DECISION DELEGATED TO HEAD OF PLANNING

Application No: H02-1171-25 **Applicant:** Mr P Blackbird
Proposal: Proposed Bungalow & Garage
Location: Rear Of 12 Peterborough Road Crowland
Terminal Date: 28th January 2026

### PLAN SHOWING SITE LEVELS

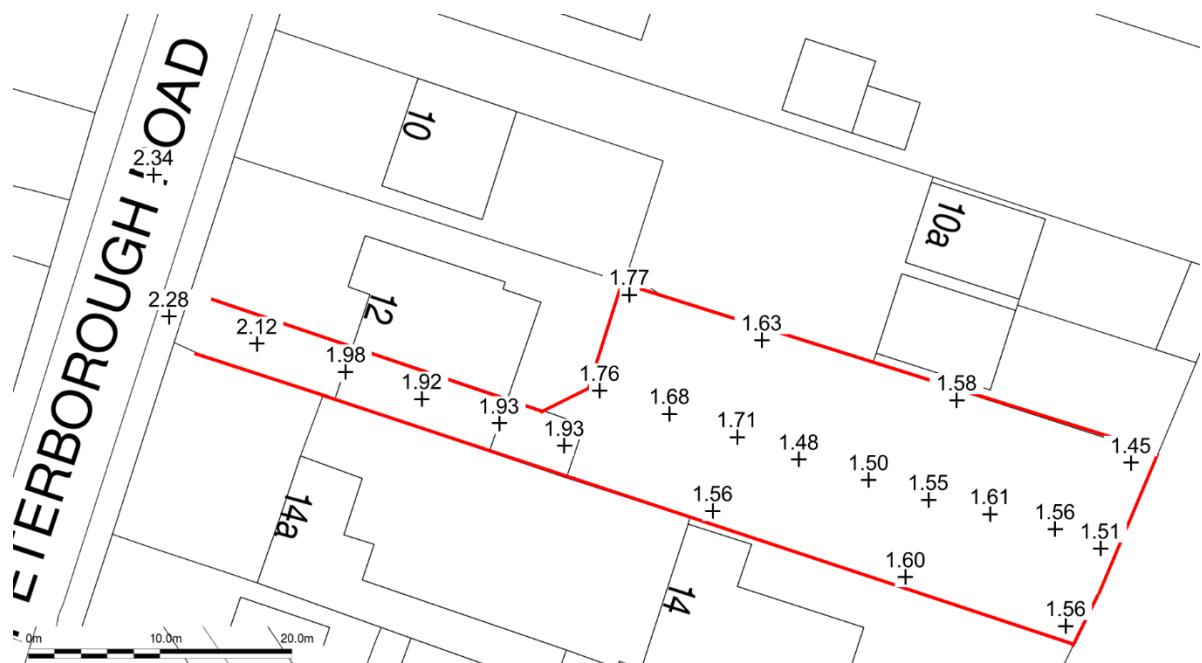
The finished floor level would be raised by 1m, giving a final level of 2.5m AOD. Page 10 of the submitted Flood Risk Assessment shows relative ground height from the road to the plot. This shows that the existing bungalow has a finished floor level of 2.05m. Condition 5 of

Elevation 01 - Front
1 : 100

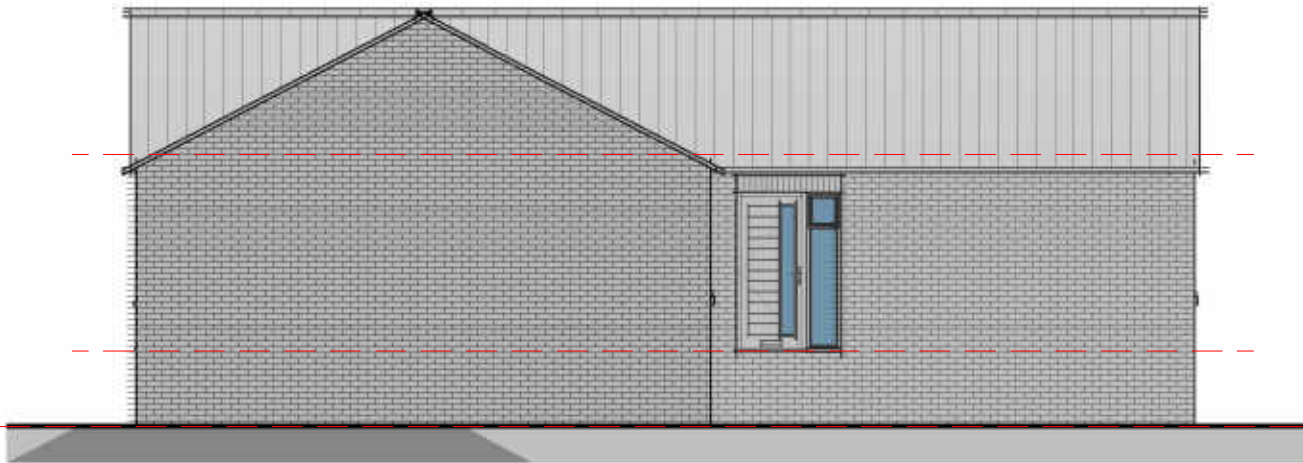
The proposed finished height of the dwelling would be approximately 5.5m to the apex. 12 Peterborough Road, which would be located in front of the proposal, has a height of approximately 5m to the apex. The proposal would therefore display an atypical relationship with the frontage development, failing to provide the expected visual subservience of backland development. This relationship is seen throughout comparable developments in the immediate area. The result is an unduly dominant and imposing form of development, at odds with the character of the area.

As outlined previously, the NPPF requires new developments to function well. The finished floor level of the dwelling would be raised by one metre. Despite this, no information on measures to ensure the dwelling is still accessible (e.g., raising the overall level of the site or providing steps to the dwelling) have been provided. Due to this lack of information provided, it cannot be said that the dwelling would function well for its lifetime.

No details of boundary treatments have been provided. As a result of the differences in finished floor levels, boundary treatments would have to be raised proportionally in order to stop views which could be obtained from the proposed kitchen and bedroom windows towards 14 Peterborough Road and from the kitchen and lounge towards 10 Black Bird Close. Such an increase in height, required to prevent overlooking, would create unacceptable visual harm. However, without this increase in height, there would be substantial overlooking to an unacceptable degree. As a result, the proposal would create an unacceptable level of overlooking, irrespective of the potential boundary treatments proposed.

Garage Elevations

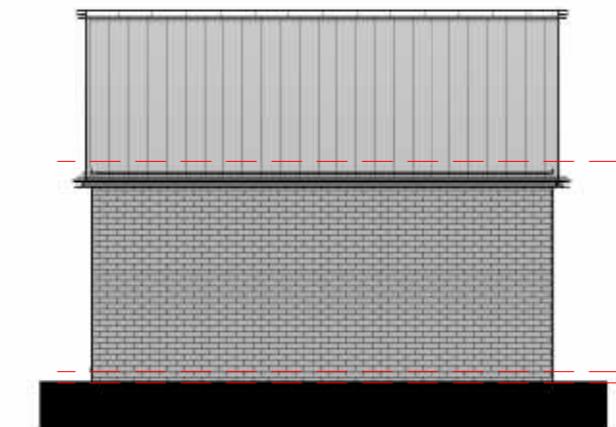
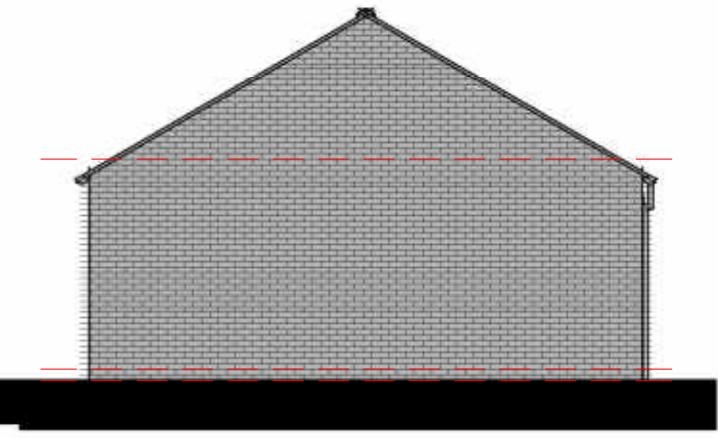
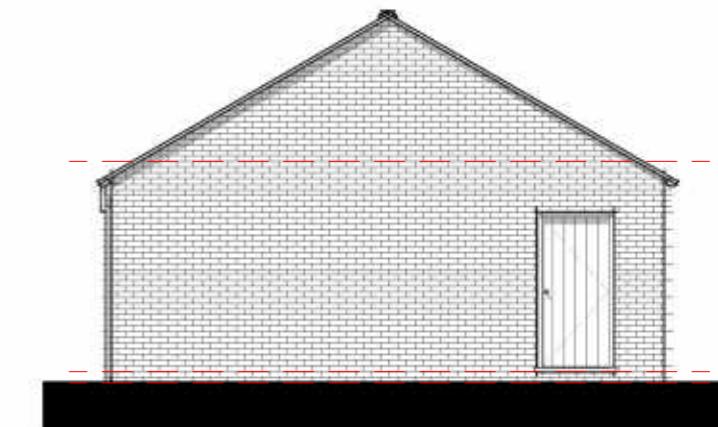
The garage would be located to the west of the dwelling. It would measure 6.1m by 7.4m. To the eaves it would measure 2.7m, rising to 4.9m at the apex.

The proposed garage would be largely obscured from the public realm by 12 Peterborough Road. However, the garage would still be highly prominent when viewed from the rear of 12 Peterborough Road. Moreover, within the plot itself the positioning to the front of the dwelling would result in a perceived increase in the scale and bulk of development. The positioning to the front of the dwelling results in attention being drawn to the feature, breaking the established coherence of the area.
